CITY OF ALBUQUERQUE

March 8, 2018

RE: **Explore Academy**
5100 Masthead NE
Grading and Drainage Plan
Engineer's Stamp Date 2/26/18
Hydrology File: D17D003N

INLET DETAIL

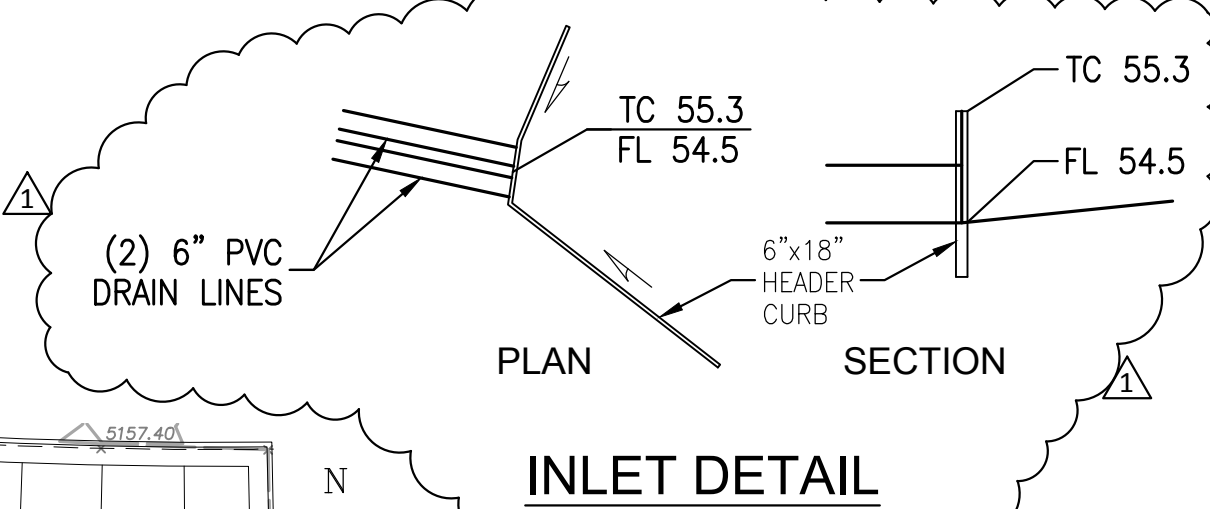
3. Runoff calculations appear to be using land treatment B for multiple zones, instead of zone 2 for the various land treatments, Please correct accordingly.
4. Provide a detail for the 6" pipe inlets. Will these have a concrete apron and end section? Will they be grated? Will there be a local depression to prevent bypass flows?
5. A Private Facility Drainage Covenant is required for the stormwater quality pond. The original notarized form, exhibit A (legible on 8.5x11 paper), and recording fee (\$25, payable to City of Albuquerque) must be turned into DRC (4th, Plaza del Sol) for routing. Please contact Charlotte LaBadie (clabadie@cabq.gov, 924-3996) or Madeline Carruthers (mtafoya@cabq.gov, 924-3997) regarding the routing and recording process for covenants.

GRADING AND DRAINAGE PLAN
WEST ADDITION

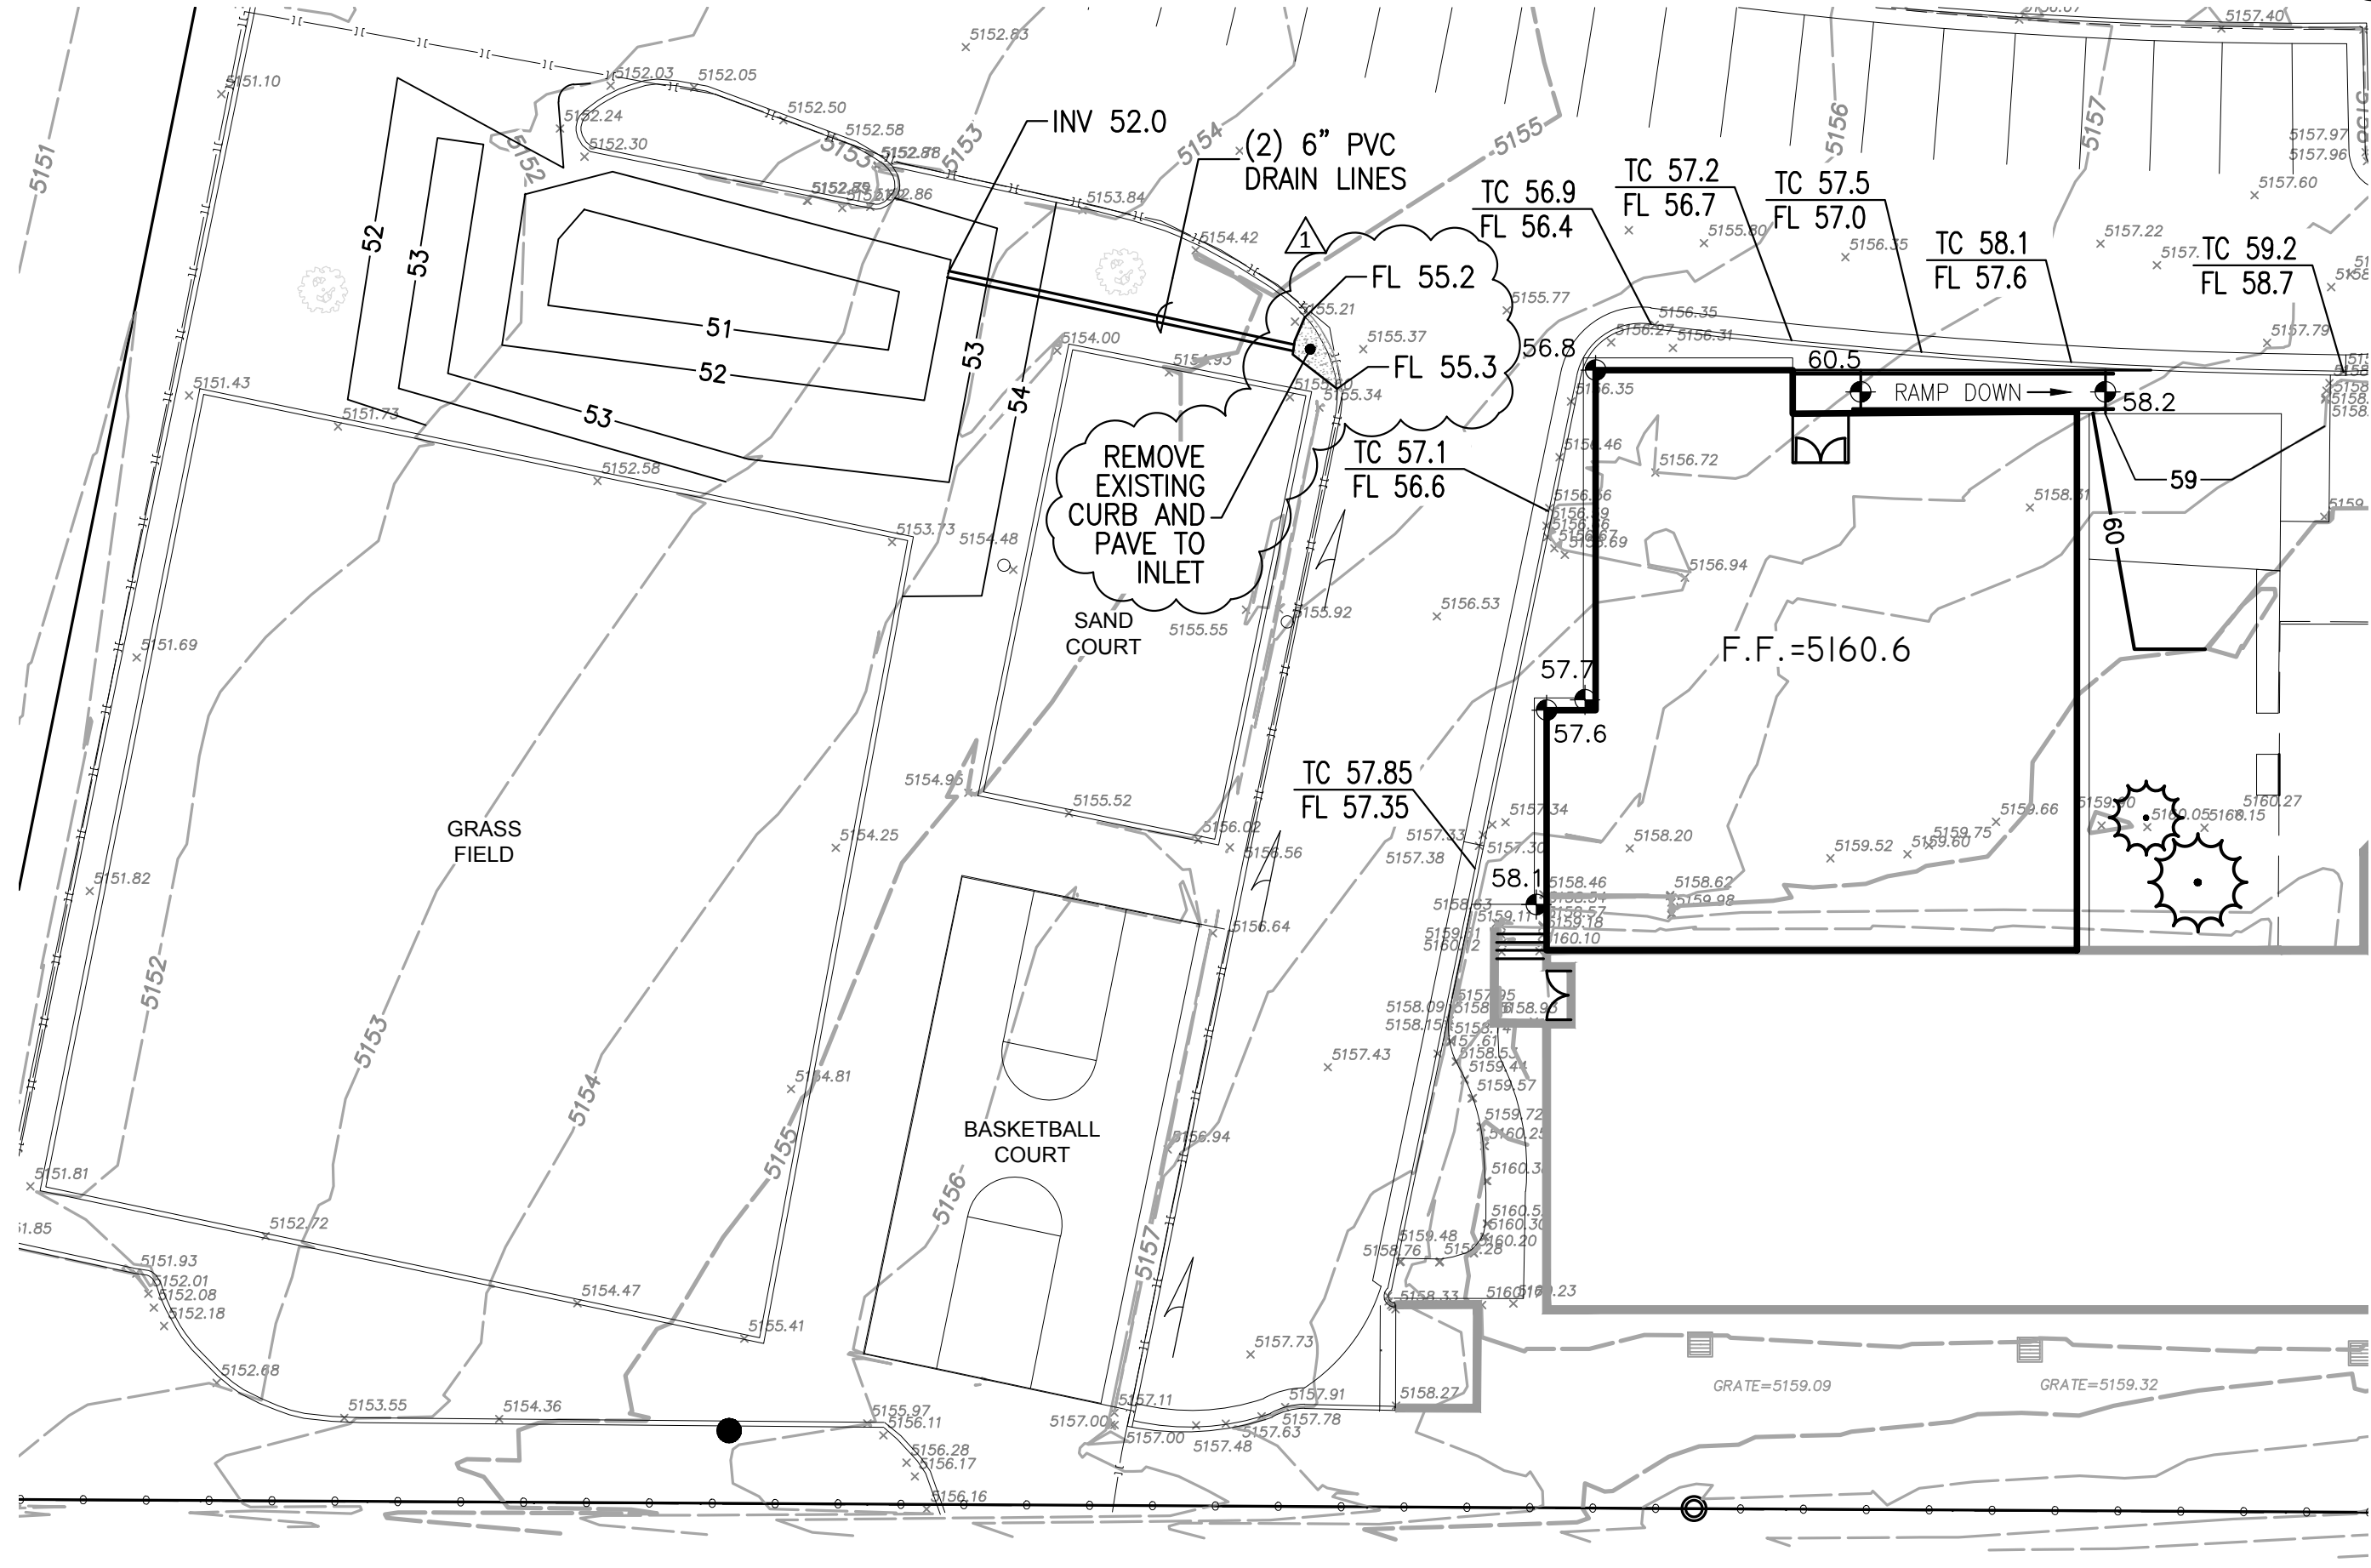
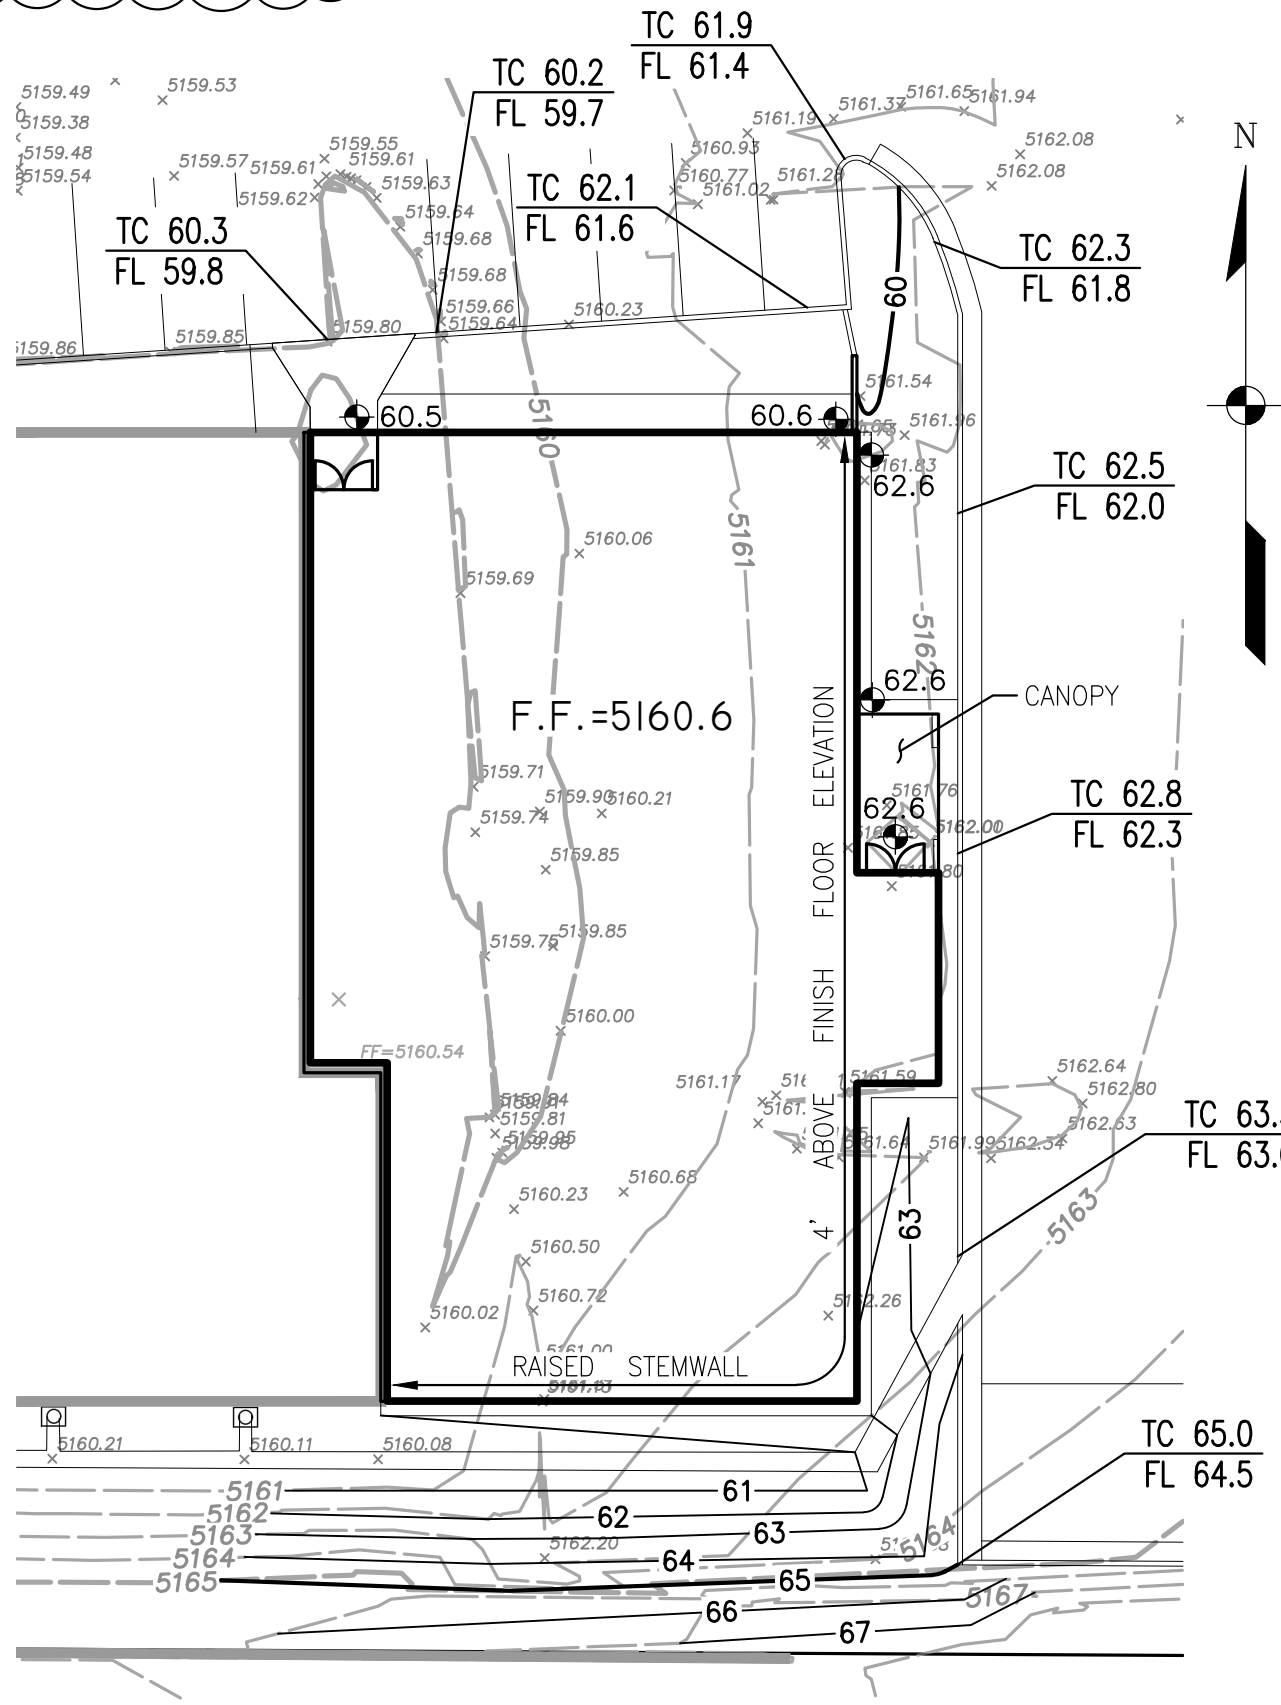
1. Delineate the subbasin that drains into the proposed pond. Demonstrate that the pond captures runoff from at least 9,950 SF of impervious area within the boundary of this parcel (equal to the first flush requirement for this re-development).
2. If not requesting Building Permit at this time, the Grading Plan needs to be labelled as "Conceptual, not for Construction" or similar. If requesting SPBP and Building Permit with this Grading Plan, forgo the conceptual markings and correct the following Building Permit items as well:
